Application No: EP/37/21/HH
Site Address: 2 South View East Preston BN16 1PX
Description of works: Replacement of cladding to gables and upper wall sections.

Thank you for your internet representation made on 18th May 2021 which has been recorded as an objection with the comments as follows:

Drawing:
Plans and elevations as proposed

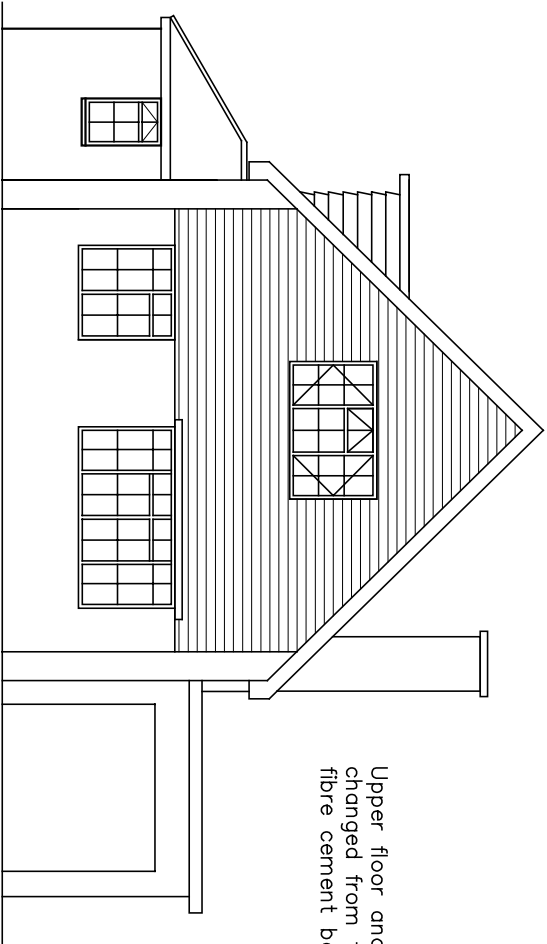
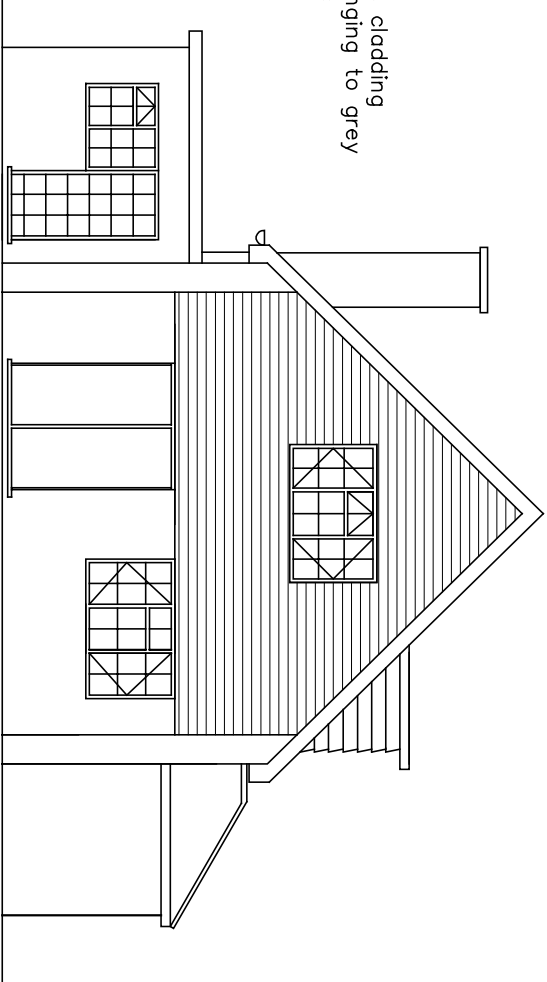
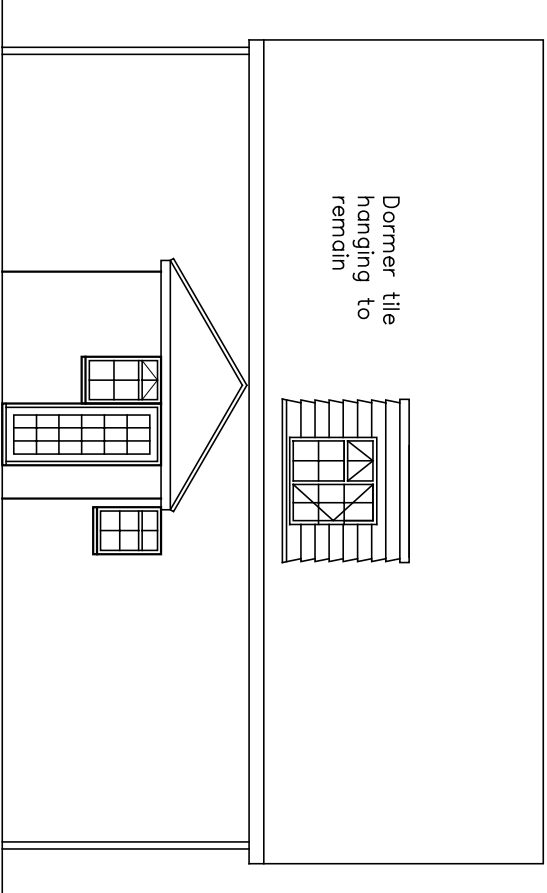
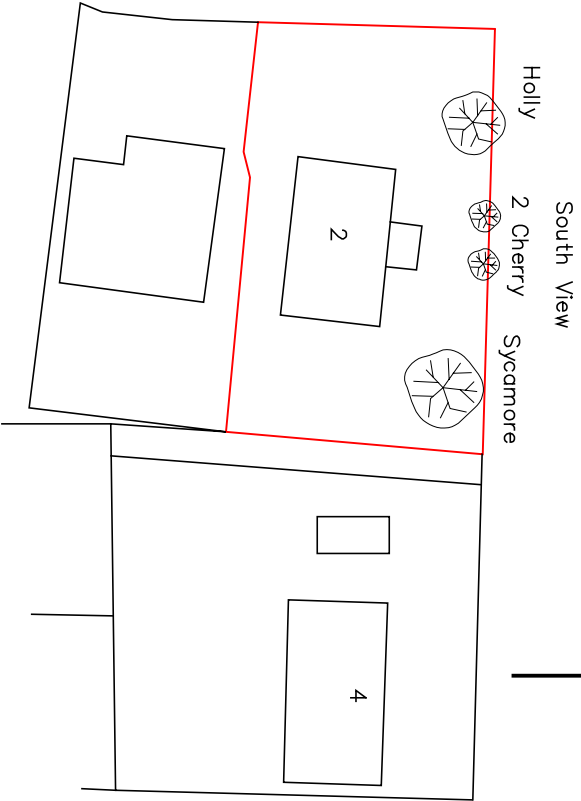
The committee agreed to object to this Application on the grounds cement cladding is not a vernacular style for the village of East Preston. As an alternative, the property to the east of the Application has retained its clay hung tiles albeit they have painted them a much lighter colour. This council is generally not in favour of New England-style cladding.
